### Stormwater Control Permit for Erosion and Sediment Control

Project Title St. Joseph's on the Rio Grande

City of Albuquerque  
Stormwater Construction Site  
Inspection Report

G11E014A

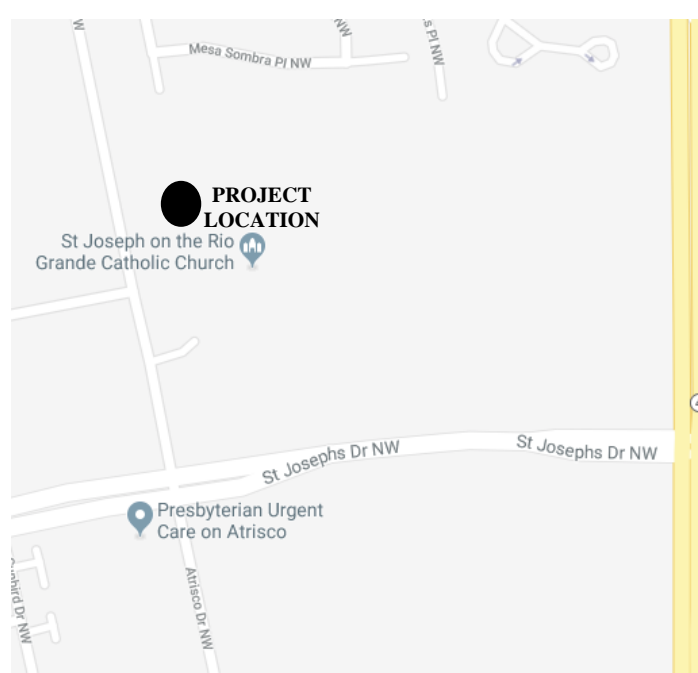
Entrance / Track-Out no dck no track out, add 4 gravel near Arisco

Sediment Controls / Silt Fence, grade too high on filter sock SW corner  
Inlet Protection, Wattles, etc.
